Item No.	Report of the Head of Development Management and Building Control	
Address:	177 STATION ROAD WEST DRAYTON	
Development:	Conversion of 8-bed HMO to 9-bed HMO	
LBH Ref Nos:	47713/APP/2024/3109	
Drawing Nos:	Location Plan 177SR_D01-D05(Approved) 177SR_S01-S06 Rev B 177SR_S11-S16 (Pre Existing) 177SR_D11-D15 (LPA)	
Date Plans received:	26-11-24	Date(s) of Amendments(s):
Date Application valid	26-11-24

Permission is sought to provide an additional bedroom, increasing the size of the property from a 8 bed to 9 bed HMO. This would be achieved through converting the room to the front of the property to enable this space to be used as a bedroom with en-suite bathroom.

drawing no D13

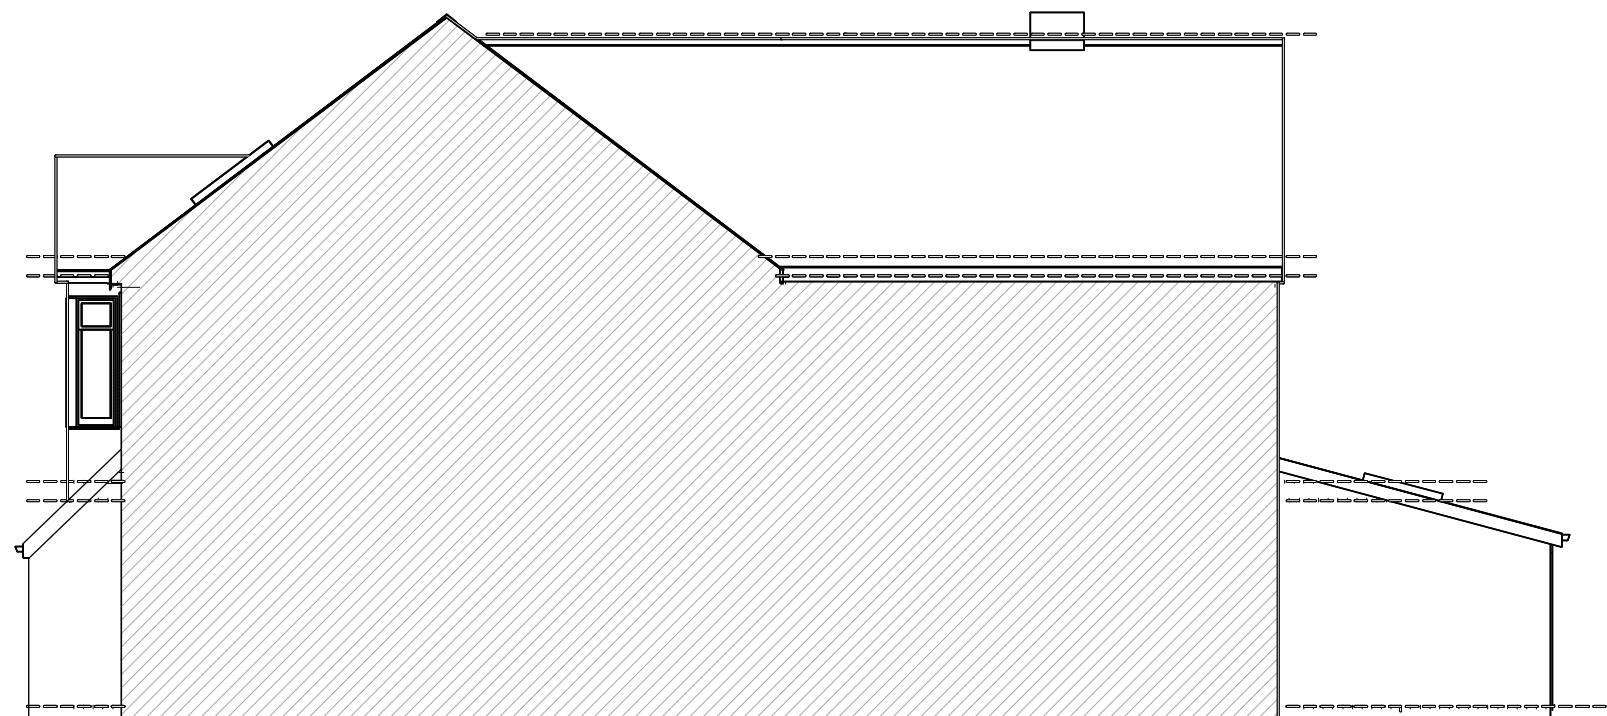
The proposals do not include external alterations to the dwelling, albeit that any regular use of the front access door is likely to cease. There is some lack of clarity in relation to the existing use of the

The conversion of the front room incorporating the consented porch results in some incoherence in terms of how this relates to the frontage of the property, however similar to the plans that were considered under planning application 47713/APP/2022/2694 the proposals retain a front door. The applicants have stated that the front door would continue to be used as a fire exit and externally would still read as a front entrance, albeit somewhat superficially.

GROUND FLOOR PLAN
Scale 1:50

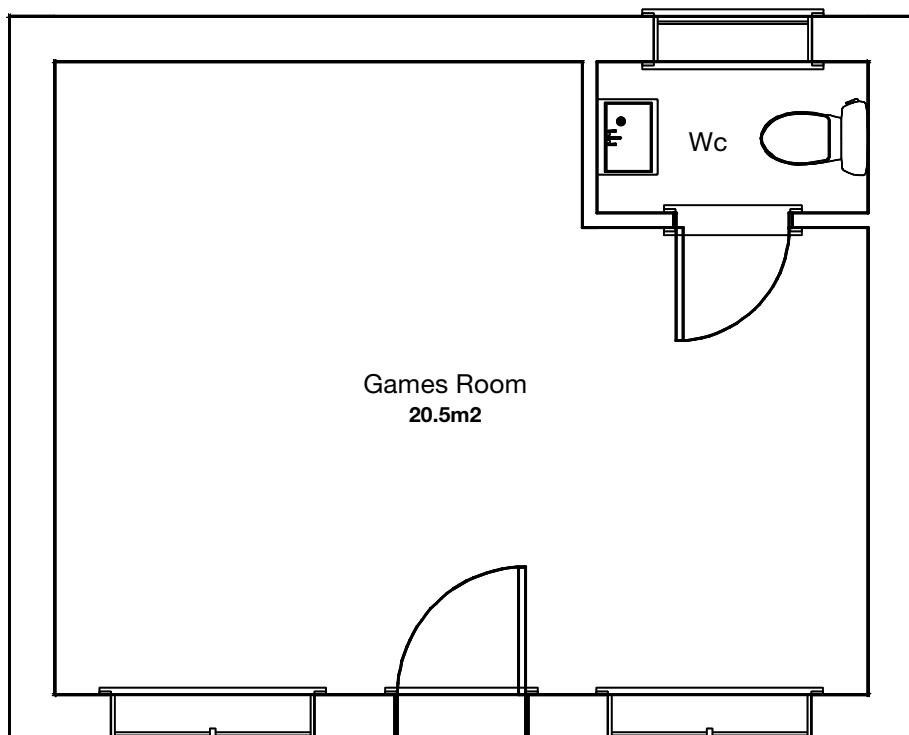
In terms of the internal living space, this comprises a kitchen/dining/living space measuring 18sqm in total area. Planning permission was granted in July 2024 (47713/APP/2024/1041) to use the property as an 8 bedroom HMO. This involved the conversion of living space to the rear of the dwelling to provide an additional bedroom, which resulted in a significant reduction in the amount of communal living space in the property.

Formerly planning permission was refused for two separate applications in 2022 to convert the front room of the property into an 8 bedroom (47713/APP/2022/2693) and 9 bedroom (47713/APP/2022/2694) HMO. Both applications were subject of a joint appeal with both appeals dismissed on the grounds that the bedroom was an inadequate size and provided inadequate living accommodation for future occupants. In both instances the proposed bedroom measured 7.7sqm in area. Whilst this was compliant with Nationally Described Space Standards for a single bedroom, the inspector noted that a higher amount of private living space should be provided given that the bedroom is the only private space that occupiers would have access to, as living and cooking facilities were communal. The inspector agreed that permission should be refused on the inadequacy of the living space associated with the front bedroom.

The proposals are put forward on the basis that were the recent planning application for a porch (47713/APP/2024/2233) to be implemented that this would increase the size of the front room to 10.5sqm. It is noted that planning permission has yet to be implemented. The works would provide a slightly larger bedroom, although this would still be relatively small and would only be classed as a single bedroom where applying the relevant space standards set out in the London Plan.

Since the previous planning application was refused the communal space has been reduced further through the provision of a bedroom to the rear of the property. It was proposed under the recent permission 47713/APP/2024/1041 that the area to front of the house would be used as communal space (as a study). The proposals would result in the loss of this communal space whilst increasing the number of occupiers present in the property.

In summary the proposals increase the number of occupiers present in the property, whilst reducing the quantity of internal communal amenity space would fail to provide adequate living accommodation, resulting in an over-concentration of occupants on site accounting for the size of the dwelling. The proposals would be contrary to Policy DMH5 and DMHB 16 of the Local Plan Part 2 - Development Management Policies; Policy D6 of the London Plan 2021; and the NPPF 2024, in particularly Paragraph 135.
